Office of
Environment
& Heritage

DOC16/611951
MP 06_232 MOD 5

Southern Highlands Regional Shooting Complex (MP 06_0232 MOD 5)

ATTACHMENT 1

Project	SOUTHERN HIGHLANDS REGIONAL SHOOTING COMPLEX	
Title	GENERAL ARRANGEMENT PLAN

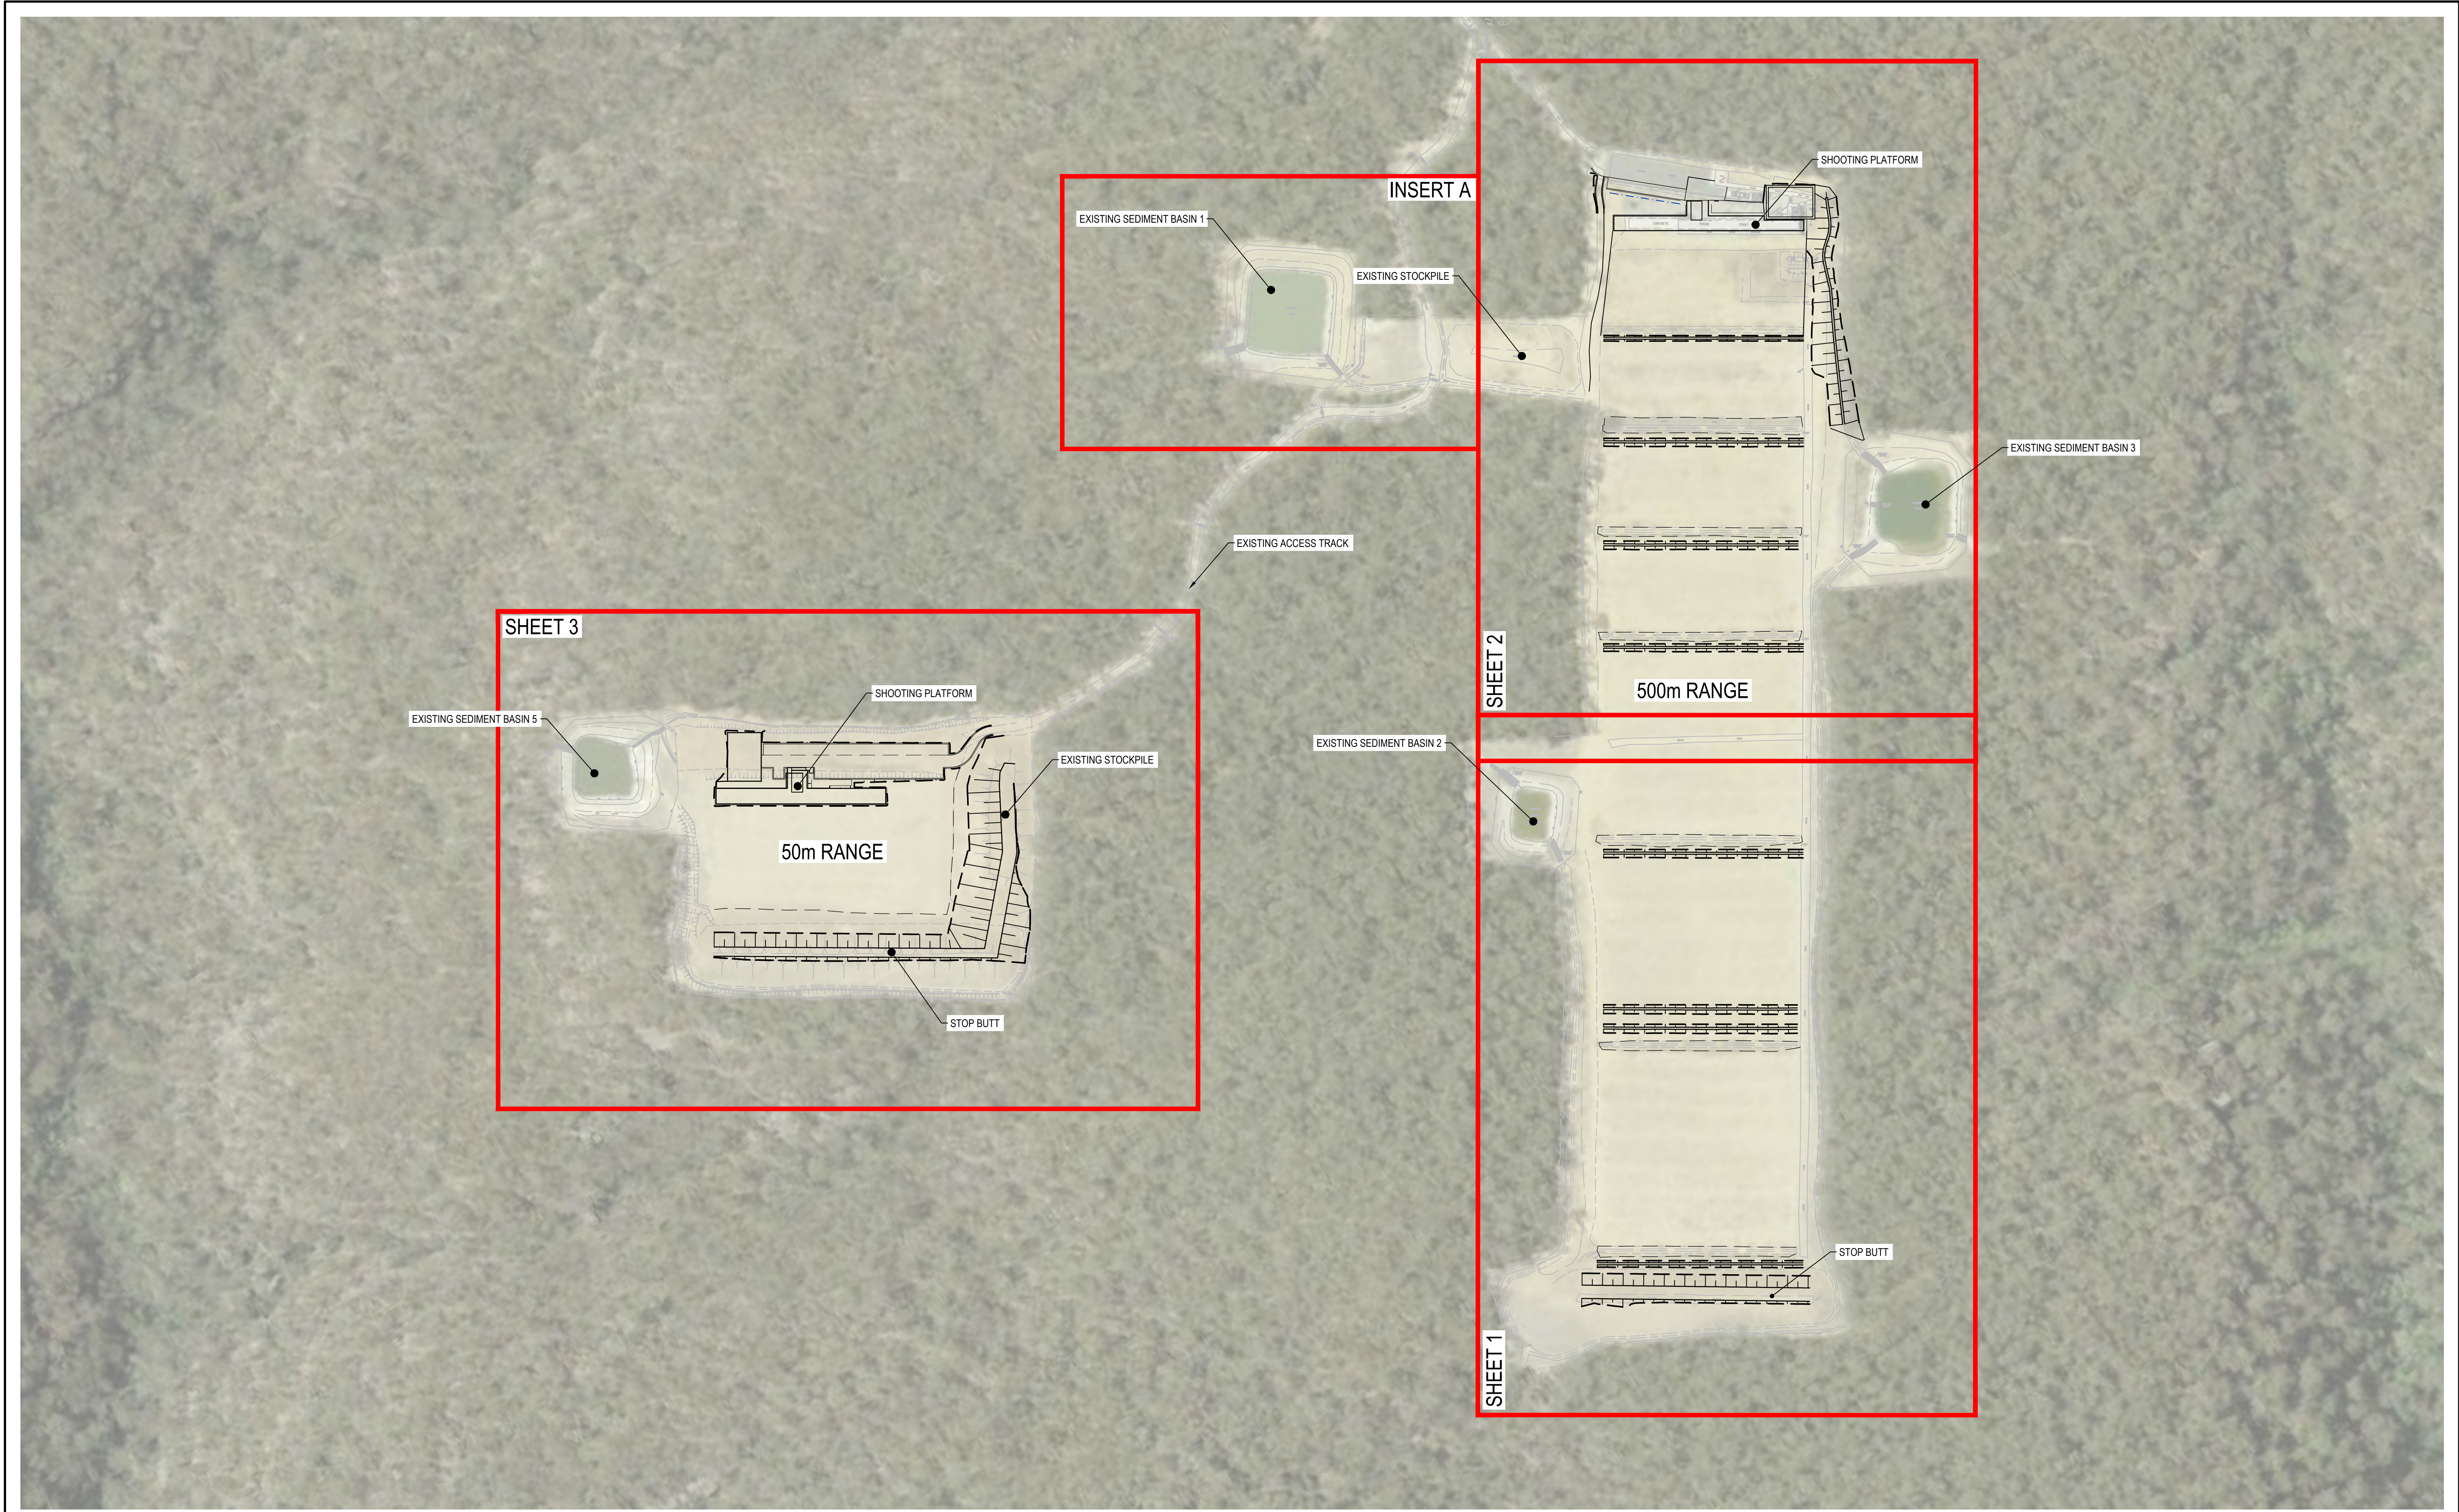
OEH notes that the plans including the Soil and Water Management Plan and Water Cycle Management Plan do not reference the Conservation Agreement. It is therefore recommended that the modification application include a plan depicting the location of the Conservation Agreement zones in relation to the existing facilities and proposed modifications and that the management plans are updated to include the Conservation Agreement area and its relevant requirements. It is advised that OEH seeks to ensure that further works will be undertaken within Conservation Agreement Zones 2 and 3 only and that construction activity will not adversely impact upon Zone 1 (with amended boundaries). The amended proposal should be designed to avoid and minimise direct and indirect impacts upon vegetated areas and native fauna, and demonstrate that lead and any other contaminants, wastewater and sediment from all of the ranges is appropriately managed and will not enter the Conservation Agreement area including waterways.

Drawing No.	Project No.	Issue
SKC014	AA008613	01

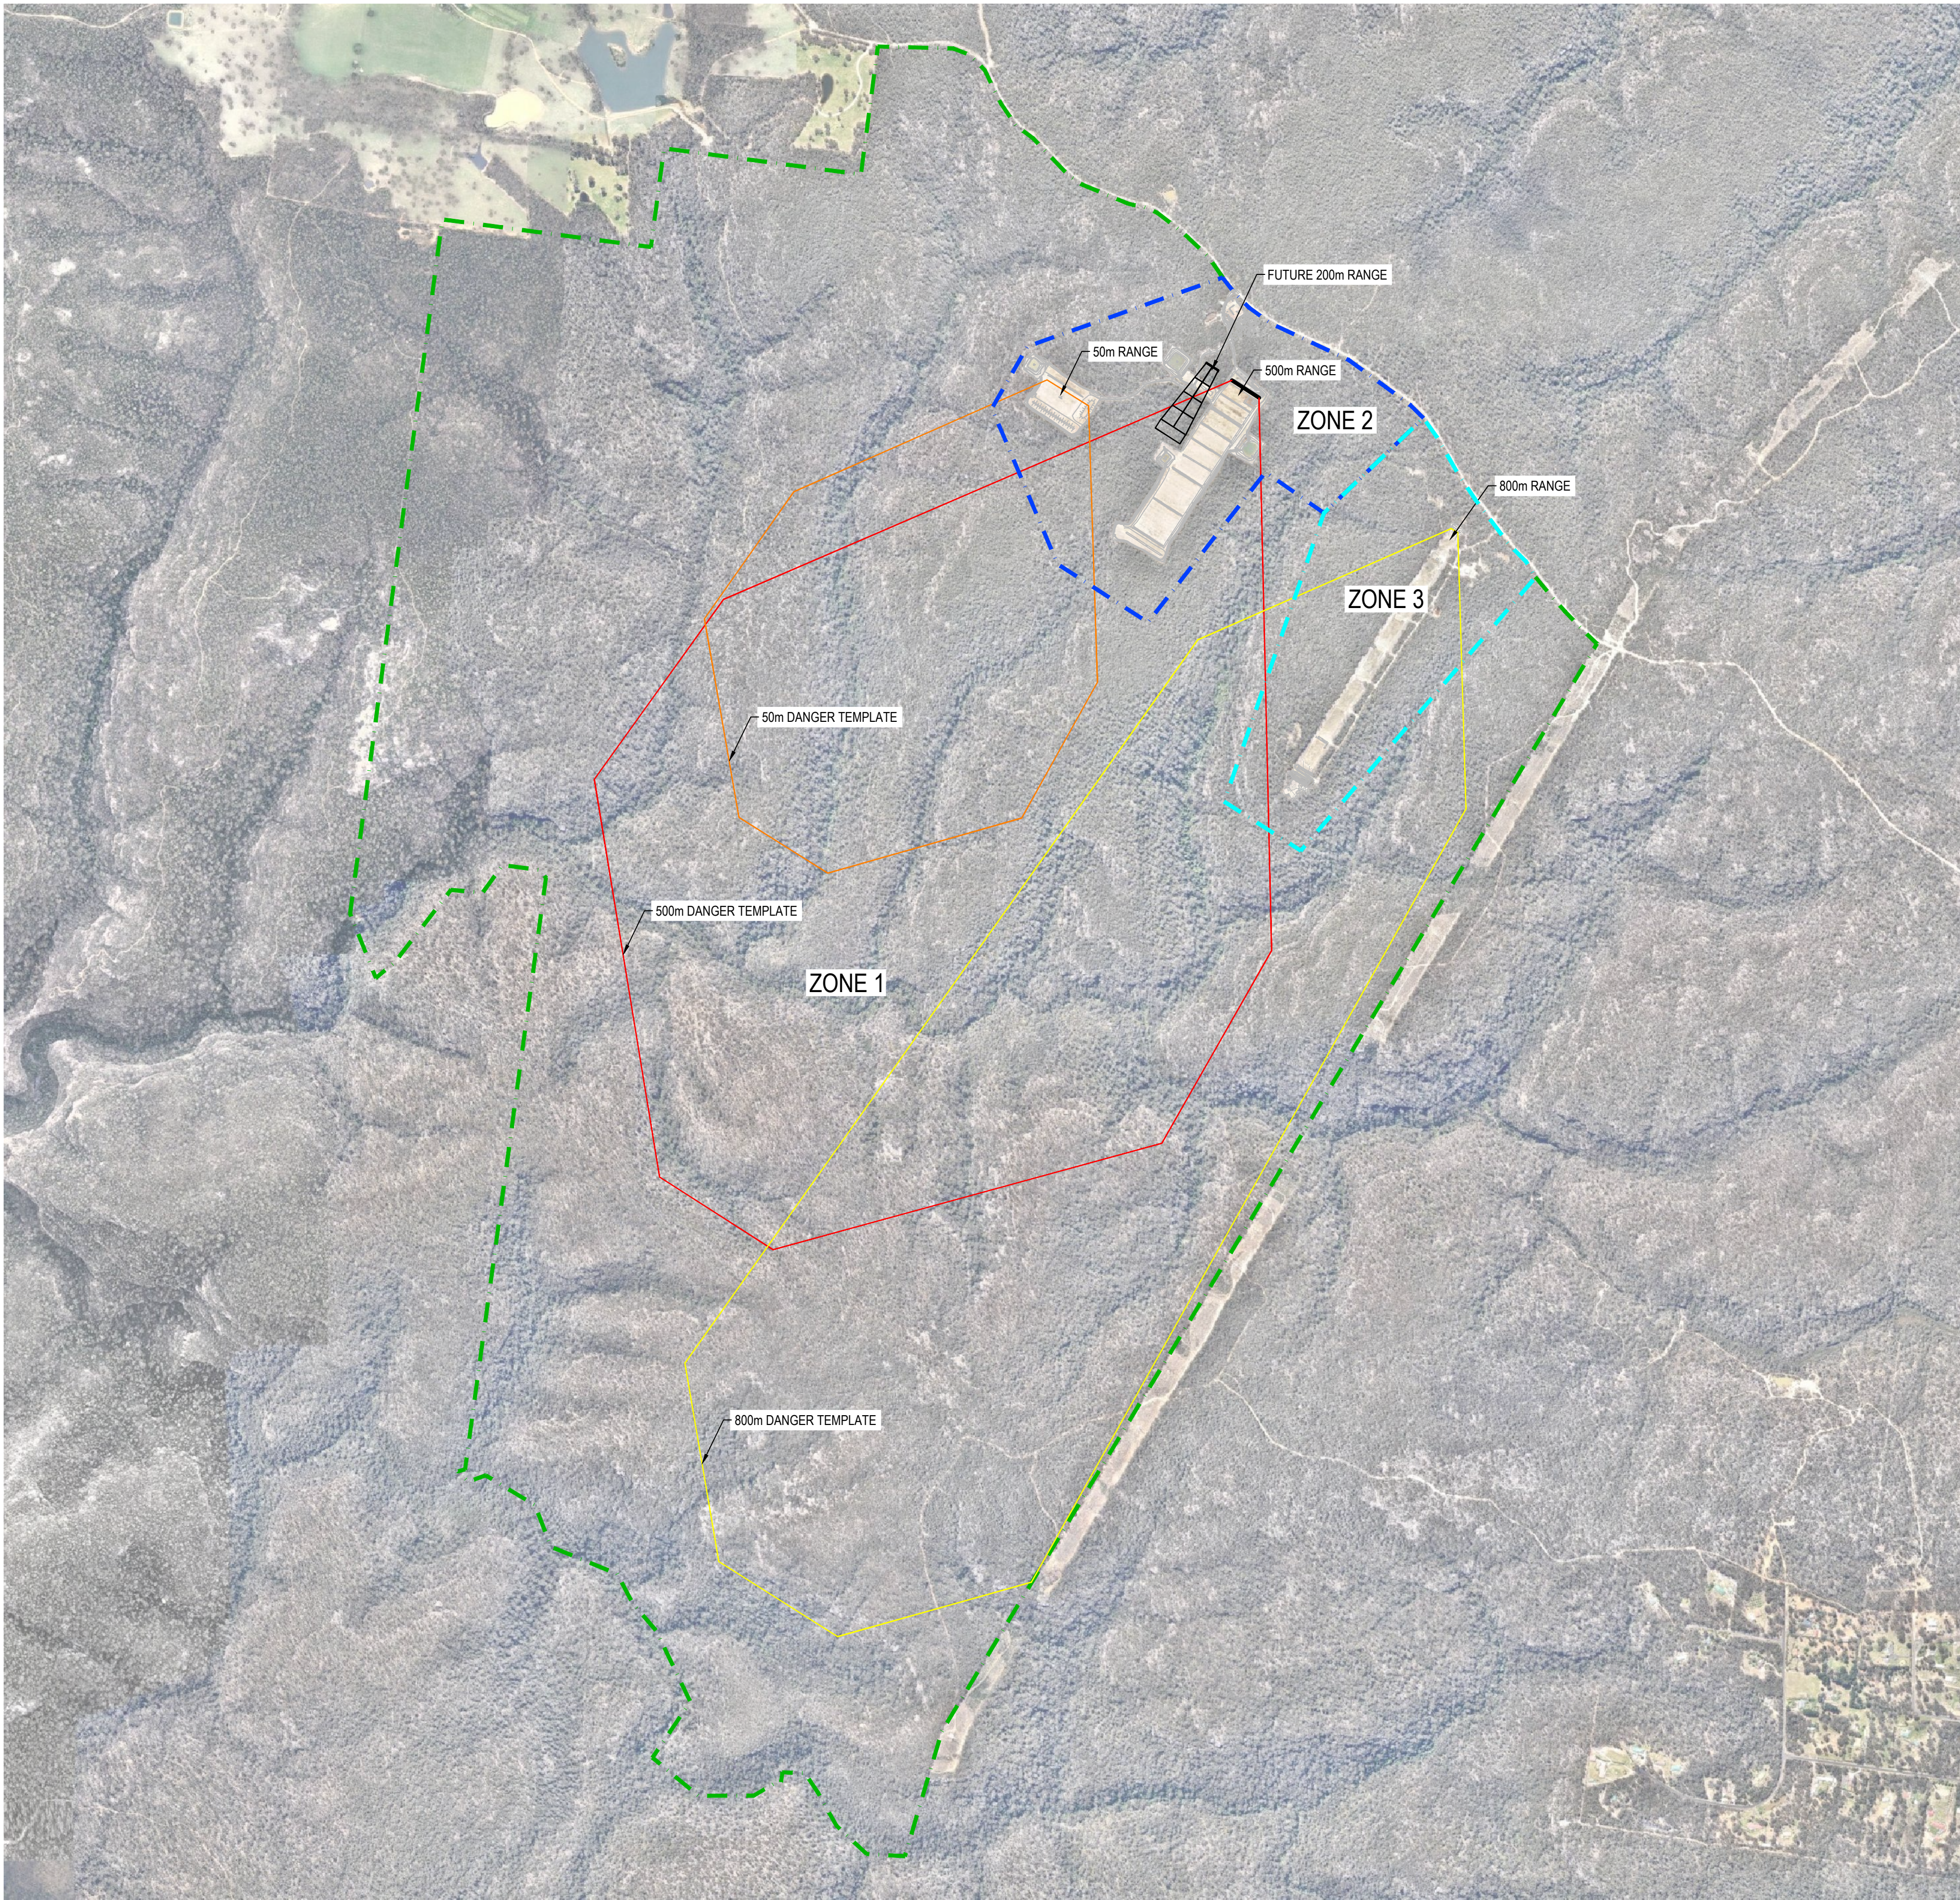
In regard to the development, OEH understands that part of the pistol range infrastructure has been constructed within Zone 1 - Bushland area. The new clubhouse as originally proposed with asset protection zone (APZ) requirements would also impact on Zone 1. Under the Conservation Agreement, this development is not permitted within Zone 1. The Office of Sport have proposed a modified boundary between Zone 1 and Zone 2 which ensures that no conservation area is lost from Zone 1 when allowing for the construction of the proposed clubhouse and APZ and existing pistol range infrastructure.
